LATE SCOPING CONSULTATION RESPONSES

From: Planning [mailto:Planning@chilternsaonb.org]
Sent: 02 August 2018 21:55
To: Expansion of Heathrow Airport (Third Runway)
Subject: RE: TR020003 - Expansion of Heathrow Airport (Third Runway)

Our more detailed comments and concerns on the Scoping Report:

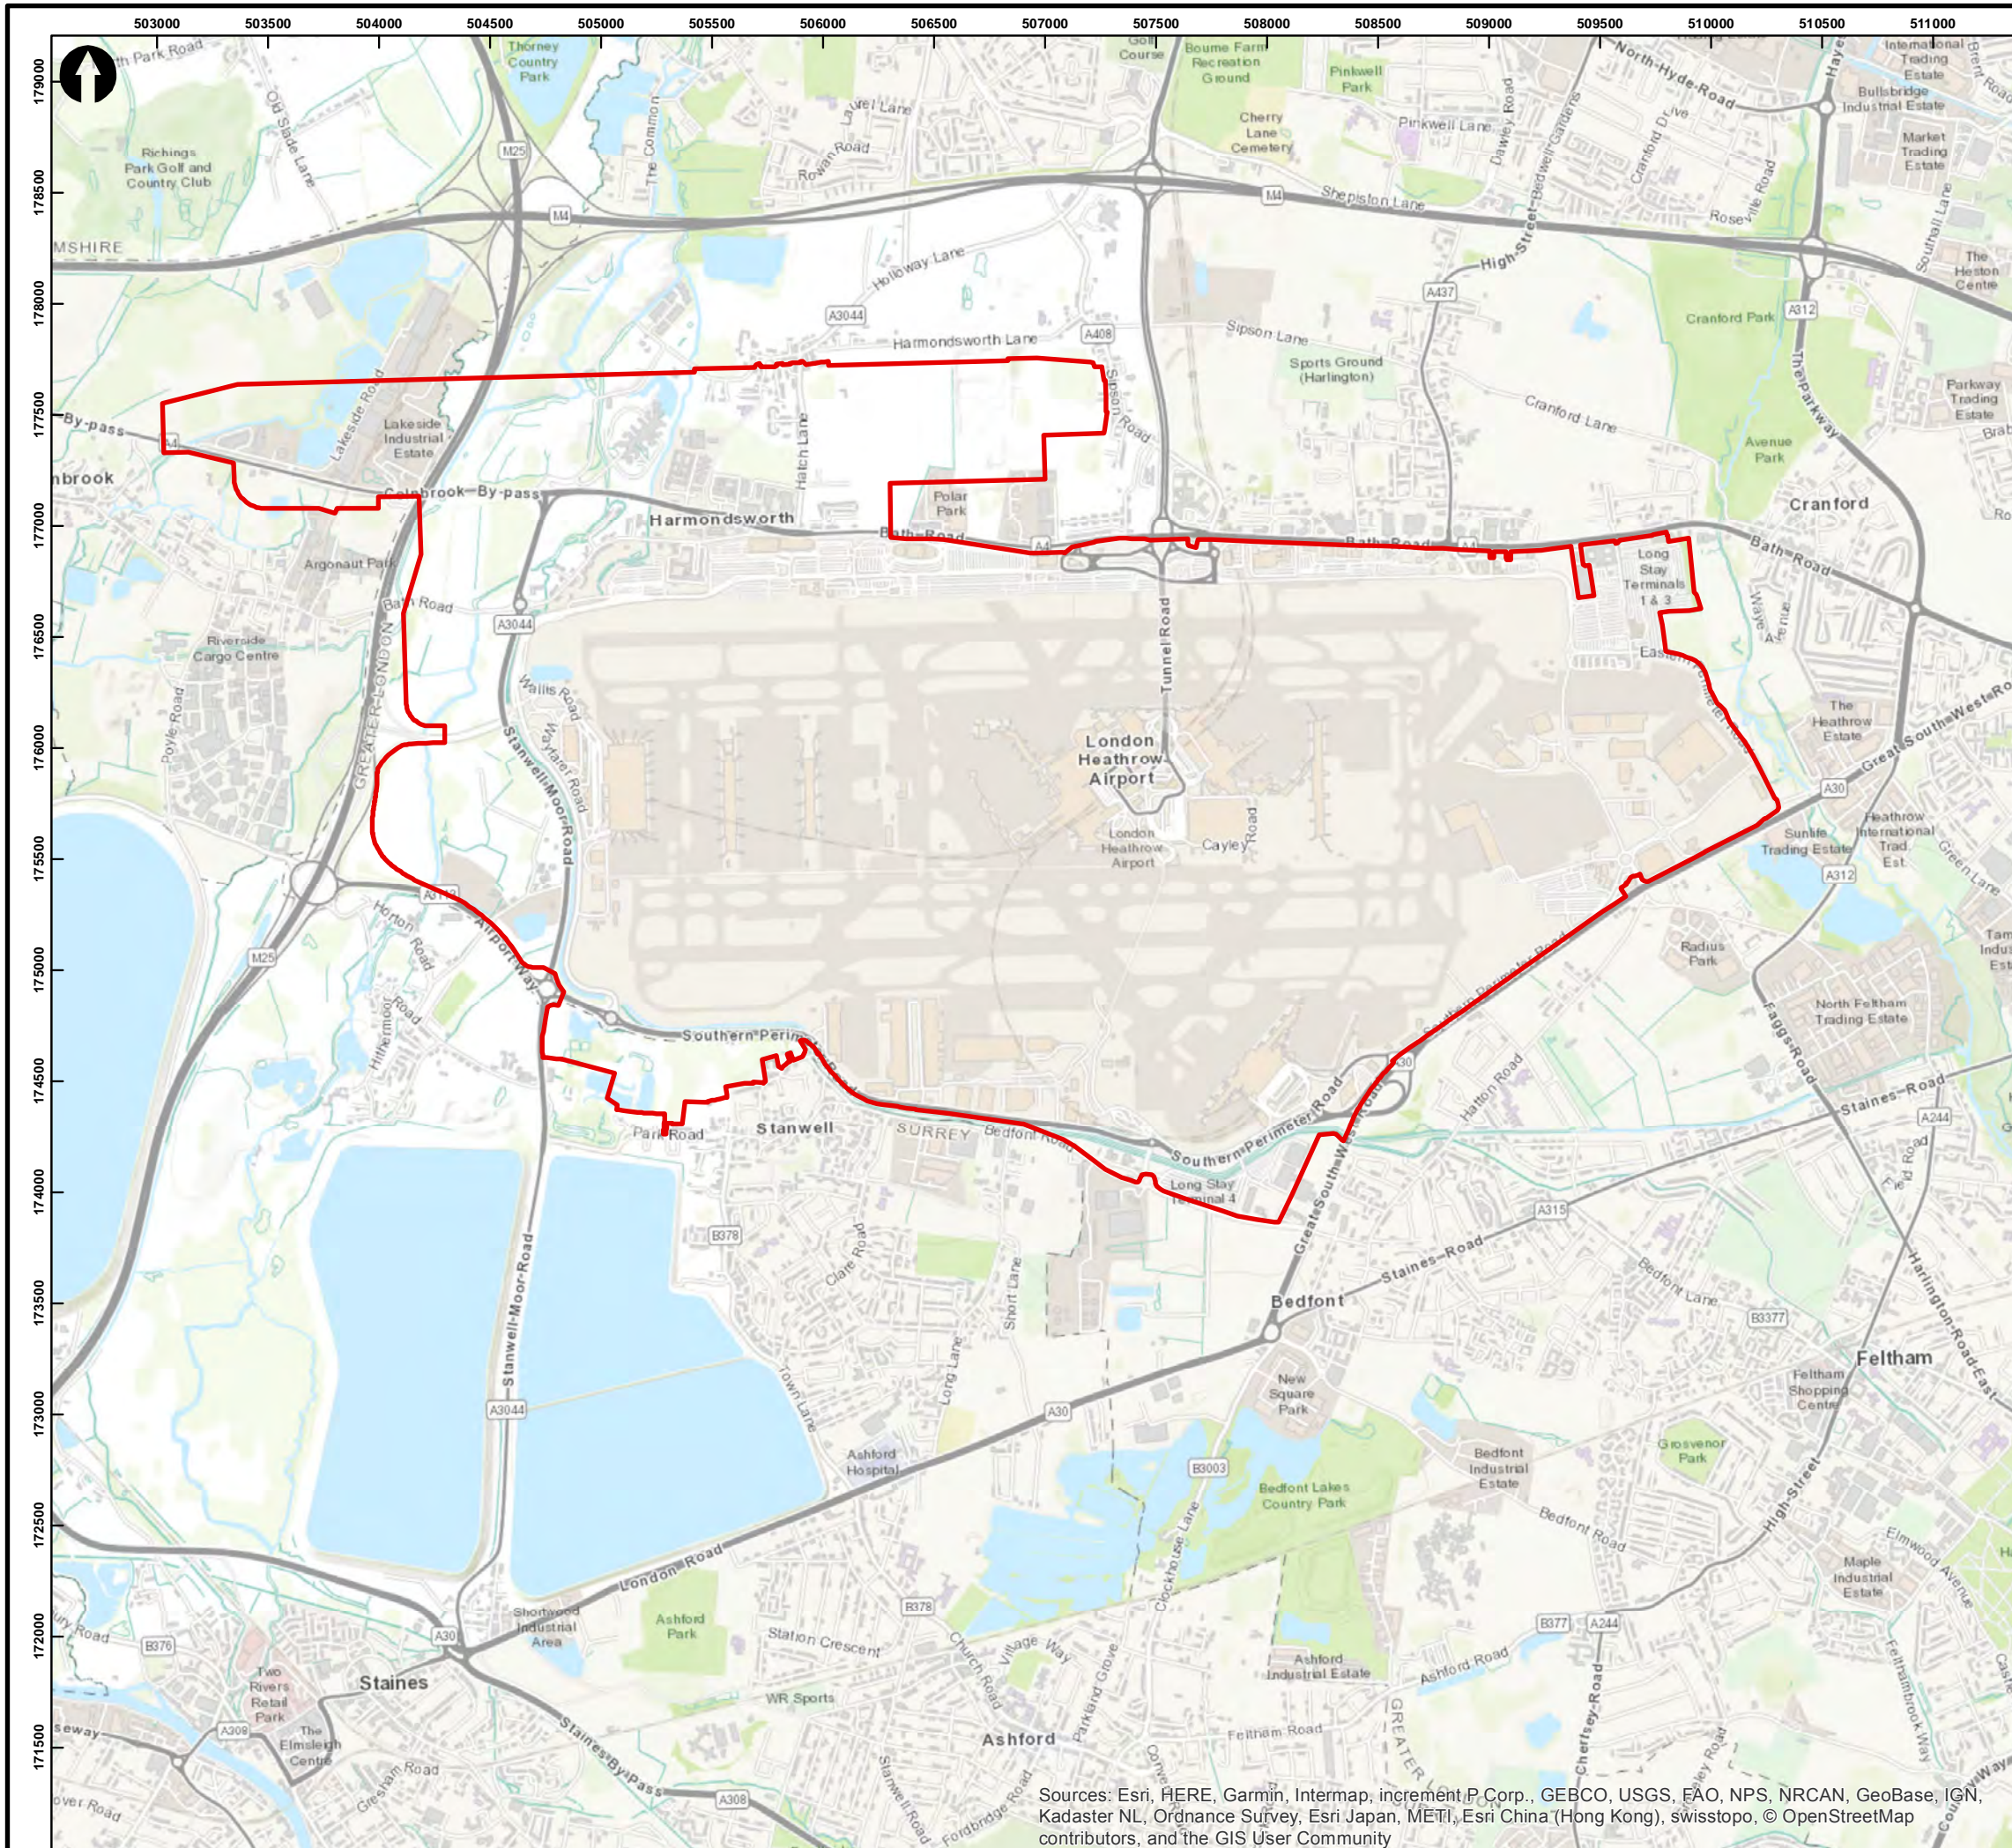
- Ch 18 Water: is the proposed study area wide enough? We like to see impacts on Chilterns chalk streams included in the "targeted monitoring" in the wider area.

Title
 Figure 5.1: Proposed 12km x 11km core AQO assessment area

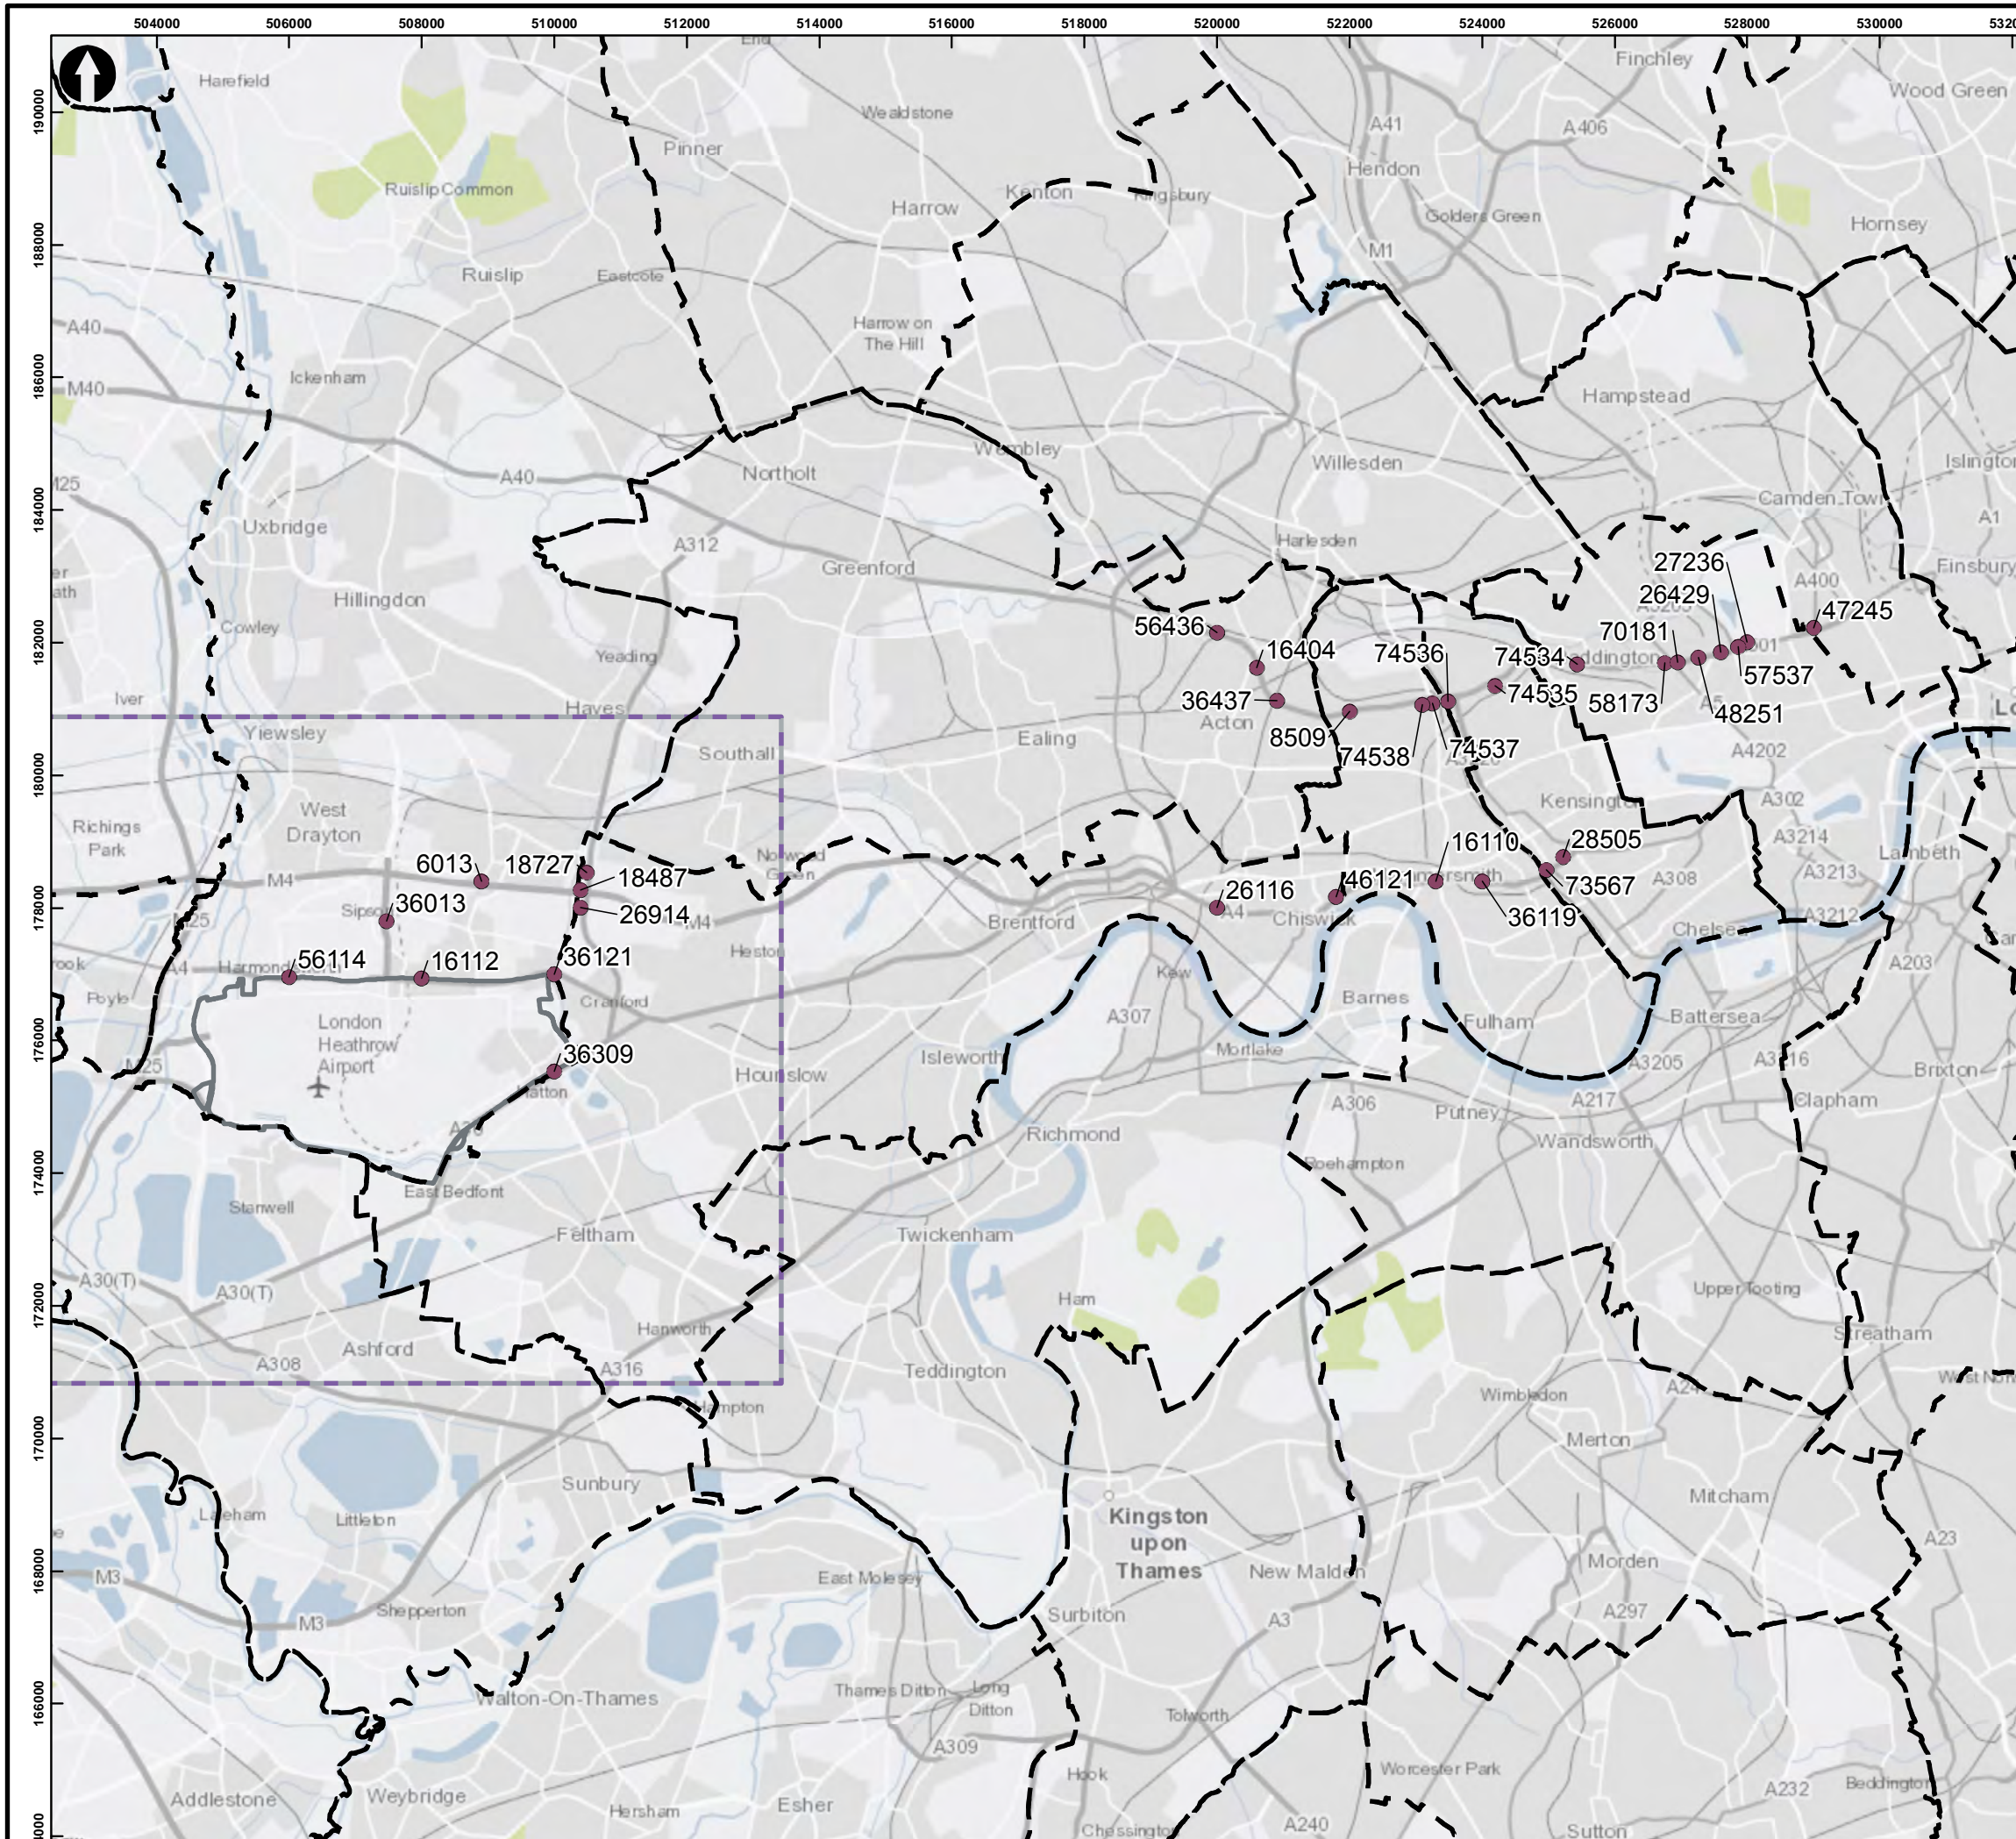
- Ch 5 Air quality: is the proposed study area (approx. 12km x 11km) wide enough?
- Ch 6 Biodiversity: is the proposed study area ("maximum amount of landtake being considered for full range of options") sufficient?

Title
 Figure 11.1: Illustrative historic environment core study area

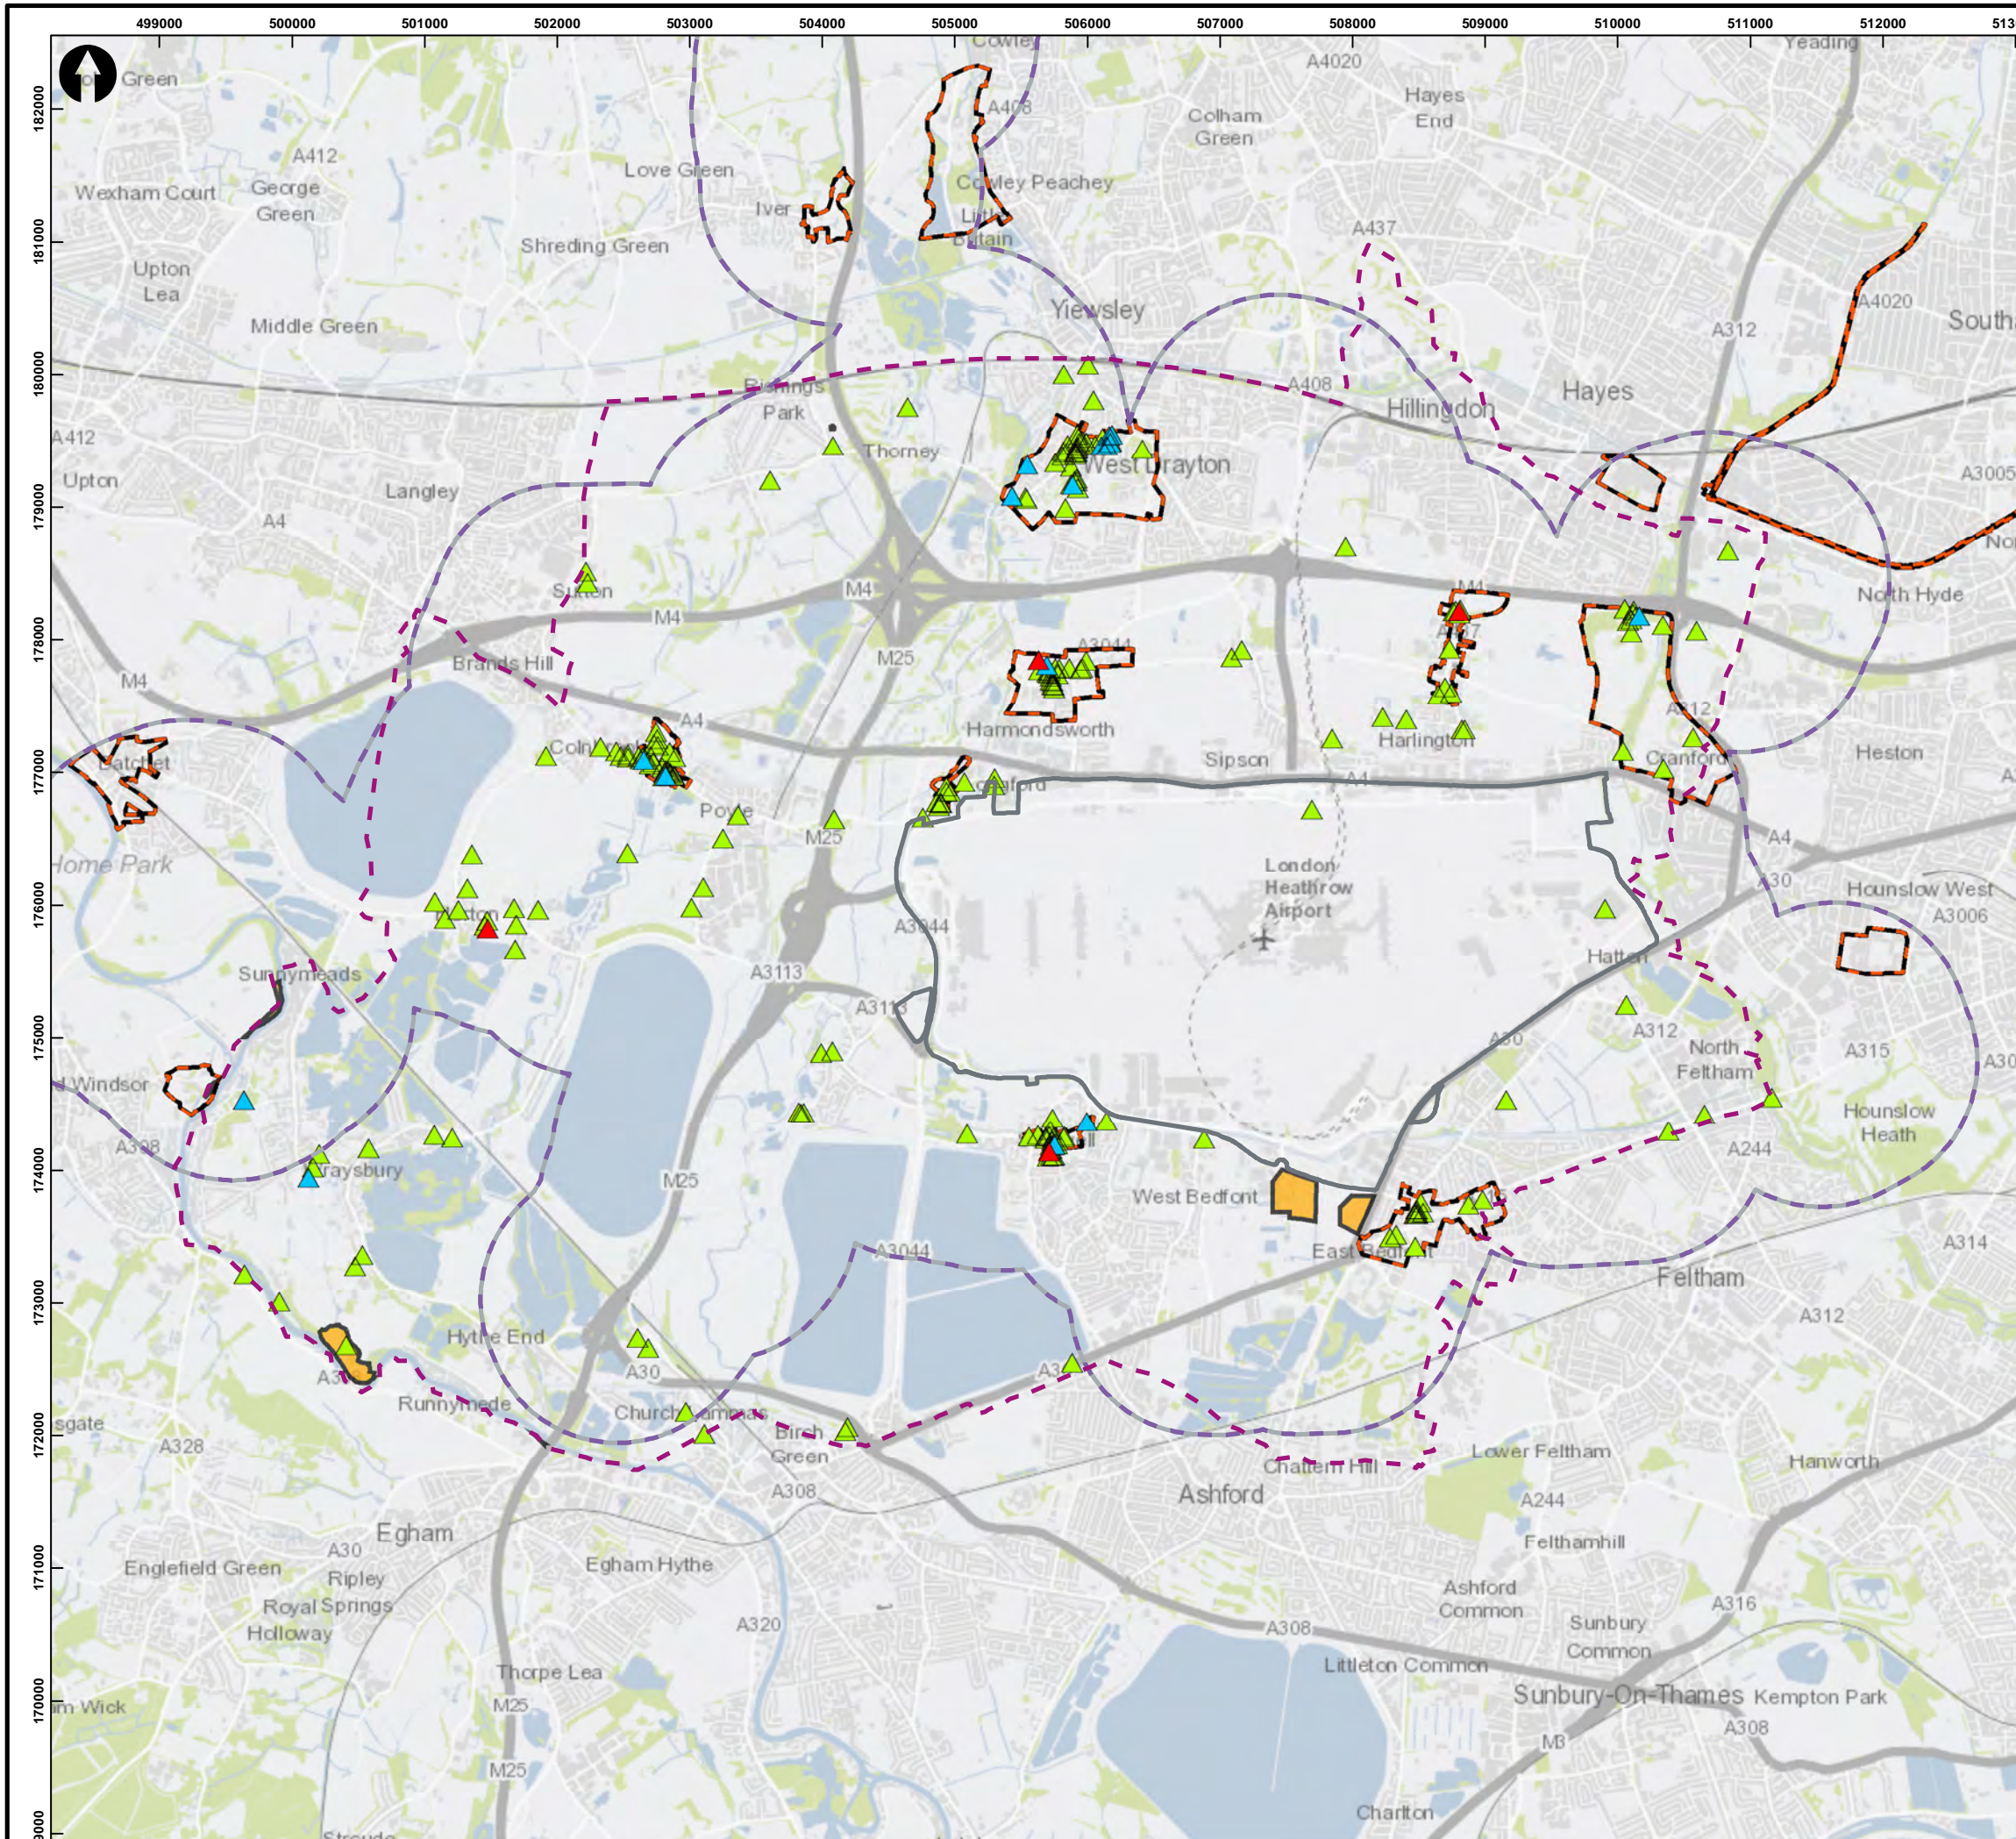
- Ch 11: We note this says that there will be a different noise study area where there is a relevant historic environment aspect (clarify bigger / smaller?)
